Thanks for the comments below, I attach drawing 501A which we have included the fin drain construction detail on to the permeable block detail as requested and updated the level information to the hydrobrake Construction Detail. The invert has been updated to 8.448 to reflect the layout design. Drawing 101 remain unchanged but I have attached for ease of reference

Subject: A/77/20/DOC

Having reviewed this application with a colleague we can confirm that we do not recommend discharge of conditions 8 and 9 at this time. We have the following comments which require addressing:

CLIENT	TL Homes		
PROJECT	Old Blacksmiths Yard Water Lane Angmering		
TITLE	Proposed Drainage and Levels Layout		
DRAWN	DATE	PROJECT NO.	22346
M Pacifico	July 2020		
ENGINEER	CHECKED	DWG. NO.	
S Doughty		REV.	
SCALE	1:100 @ A1

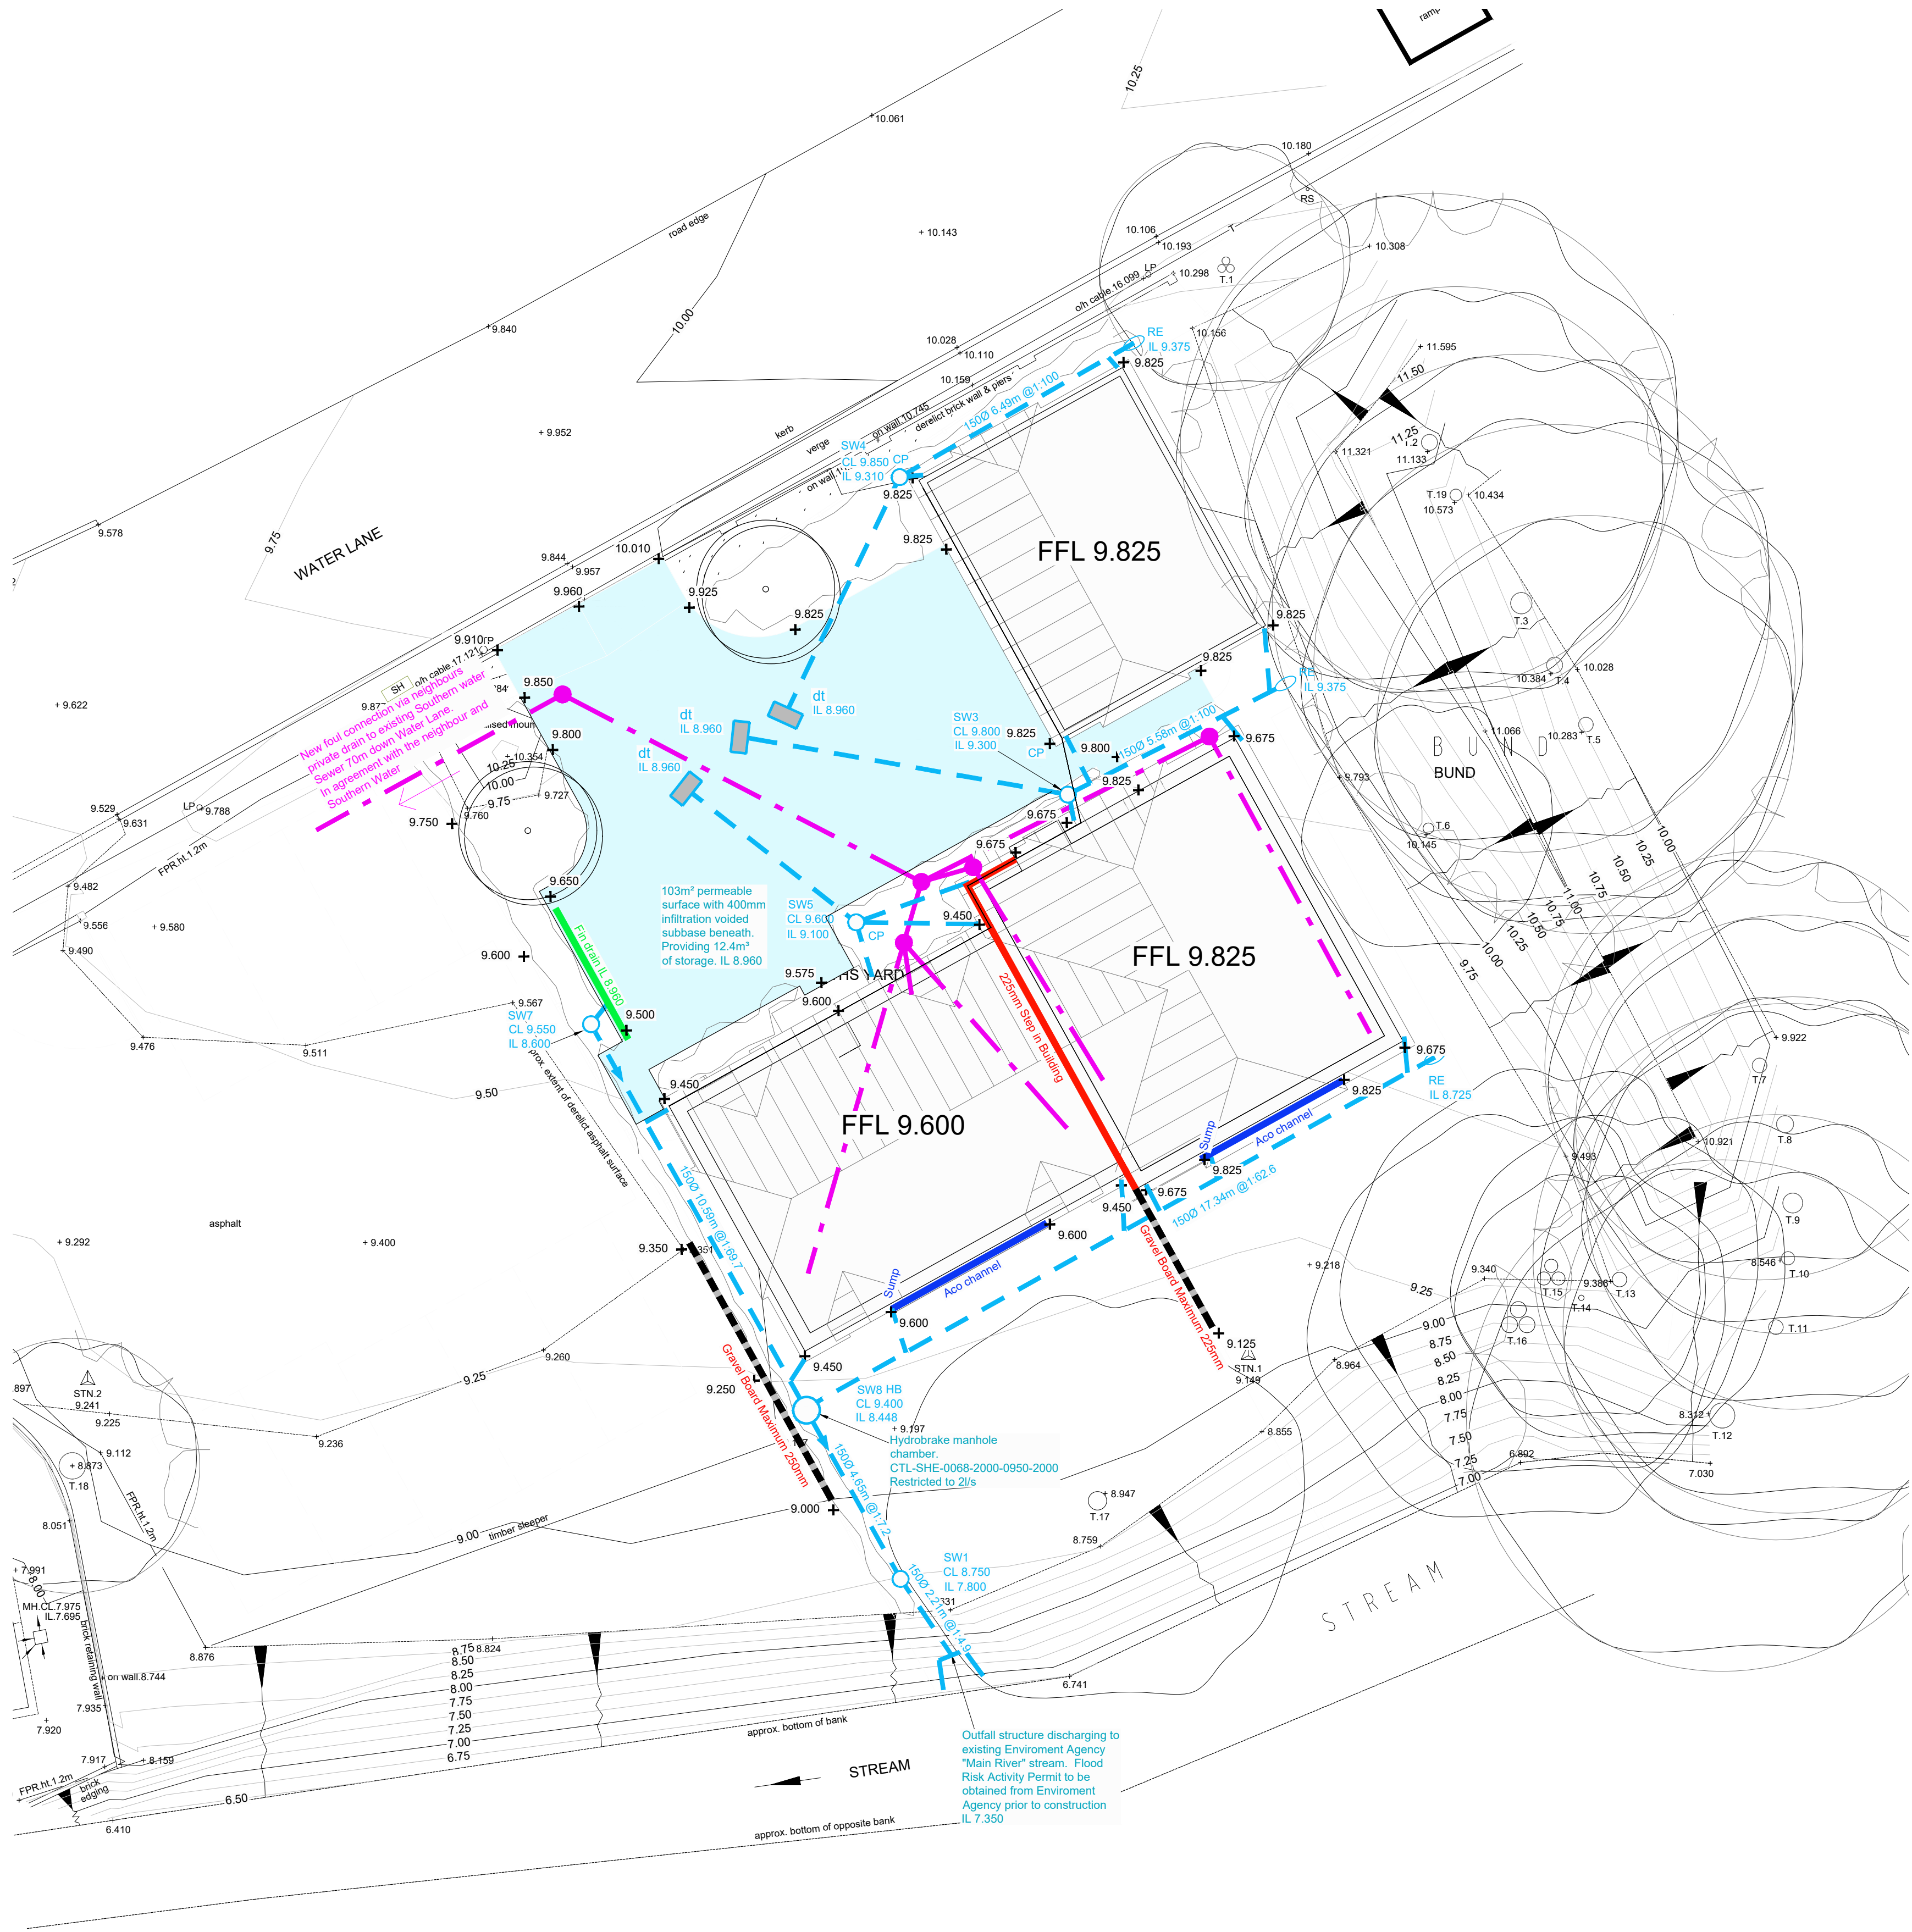
4. The drainage strategy layout is cramped and not clear. Please provide a plan that is to scale and includes the following additional features; a) pipe materials and dimensions for all pipes b) invert levels of diffuser blocks and fil drain c) cover levels and cover types of all inspection chambers/manholes d) finish levels of permeable paving (we note that two ground levels are stated, please make it clear if these are proposed ground levels and include a further level near the garage)

7. The layout states the hydrobrake will have a design head of 0.5m, this is inconsistent with the calculations and construction details. Please correct.

4. The drainage strategy layout is cramped and not clear. Please provide a plan that is to scale and includes the following additional features; a) pipe materials and dimensions for all pipes b) invert levels of diffuser blocks and fil drain c) cover levels and cover types of all inspection chambers/manholes d) finish levels of permeable paving (we note that two ground levels are stated, please make it clear if these are proposed ground levels and include a further level near the garage) We have taken on this project and provided a new set of drawings and details which we trust are clear.

7. The layout states the hydrobrake will have a design head of 0.5m, this is inconsistent with the calculations and construction details. Please correct. We have detailed a bespoke hydrobrake for the project and the model and details provided are all consistent.

PERMEABLE BLOCK PAVING DRIVE CONSTRUCTION
VOIDED SUBBASE TANKED SYSTEM
(Scale 1:20)

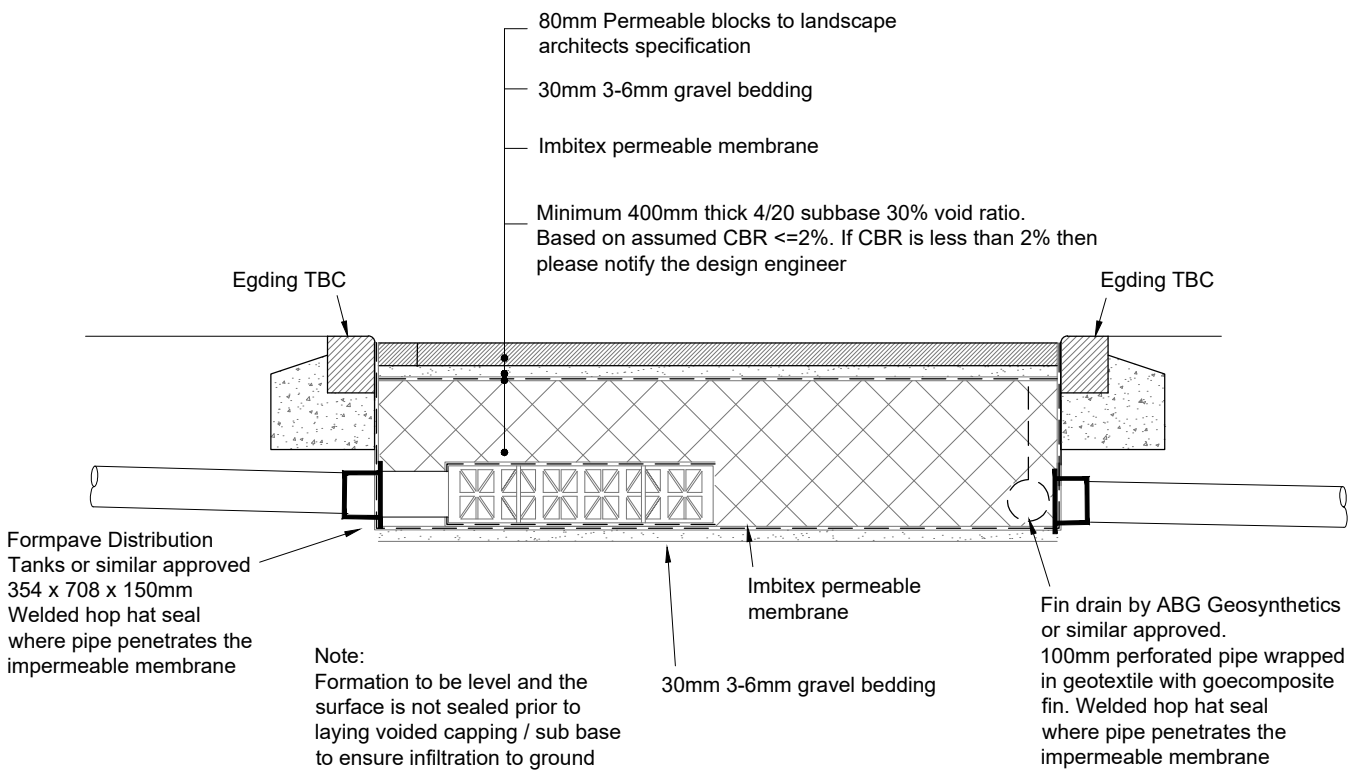
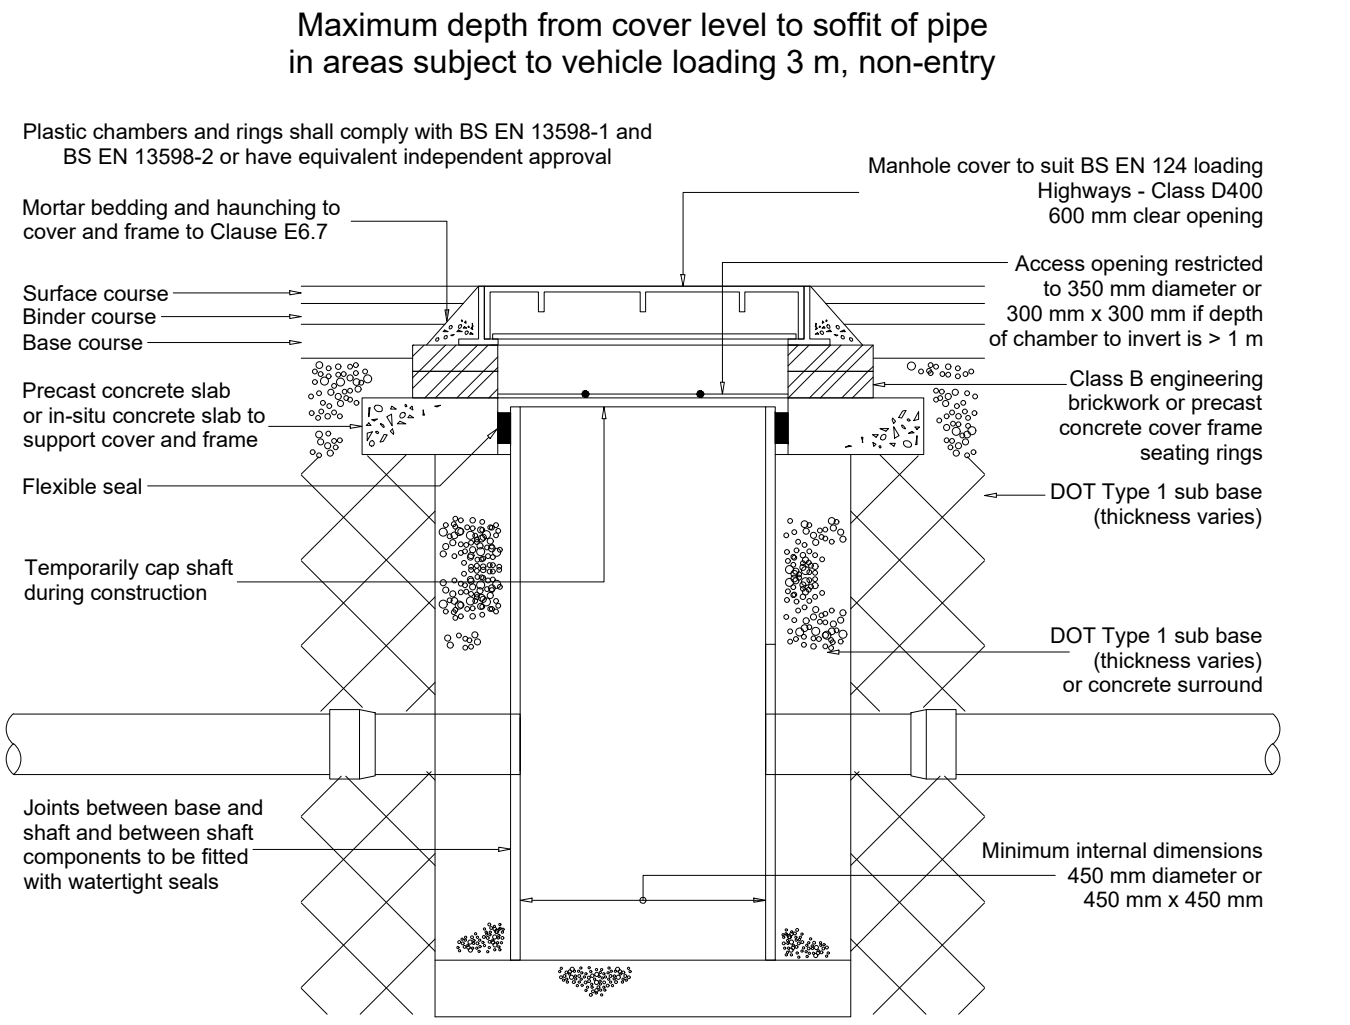
1. The construction detail for the hydrobrake has some inconsistencies, specifically invert level and design head. Please correct.
2. Please can you also provide a construction detail drawing for the Fin Drain.

10. Please provide construction detail drawings of permeable paving, aco channel, manholes and catchpits. The permeable paving detail currently provided is not site specific and lacks material specification detail.

10. Please provide construction detail drawings of permeable paving, aco channel, manholes and catchpits. The permeable paving detail currently provided is not site specific and lacks material specification detail. Provided on Drawing 501.

5. Please provide silt traps upstream of all connections into the permeable paving.
6. We note that a Fildrain is proposed to collect water from the permeable paving sub-base and would ask whether collection via a diffuser block may provide a better means to collect water. This is not a point that would warrant us refusing discharge of conditions but is worth considering from a construction and maintenance perspective. We will however need invert levels of the foul drain to ensure no clash between the fildrain and sewer.

5. Please provide silt traps upstream of all connections into the permeable paving. We have indicated catchpit manholes on the plan and in the schedule which are located upstream of the distribution tanks to act as silt traps, we have provided a catch pit detail with a 500mm deep sump on the construction details drawing.

MANHOLE SW11 - HYDROBRAKE
(Scale 1:20)

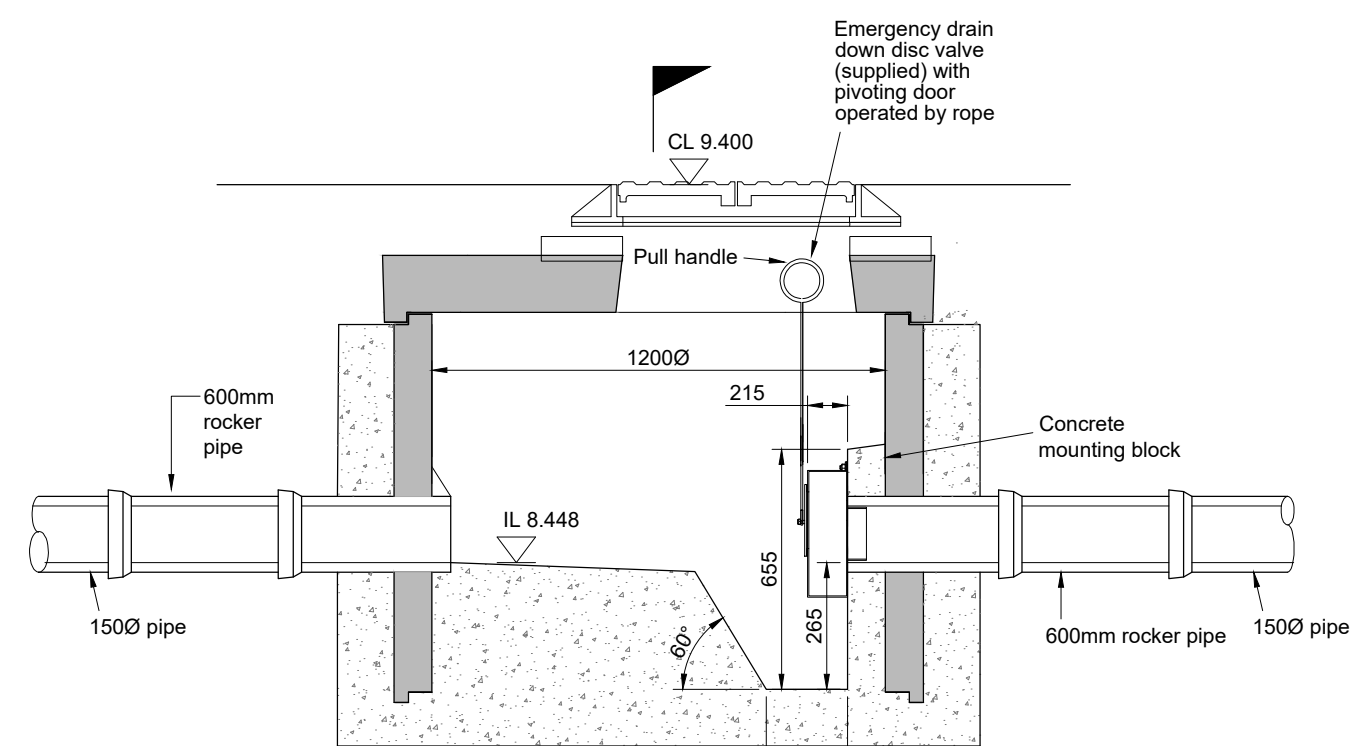
8. The hydrobrake construction detail needs to be site specific, i.e. include invert levels and cover levels. Step rungs should also be provided.
9. Please provide pipe bed and surround details that are consistent with approved document H.

The design head on the calculations is set at 950mm to prove the system before the hydrobrake manhole will overtop.

8. The hydrobrake construction detail needs to be site specific, i.e. include invert levels and cover levels. Step rungs should also be provided. We have detailed a bespoke hydrobrake for the project and the model and details provided are all consistent. We have not provided step rungs to this chamber as we do not wish to encourage access.
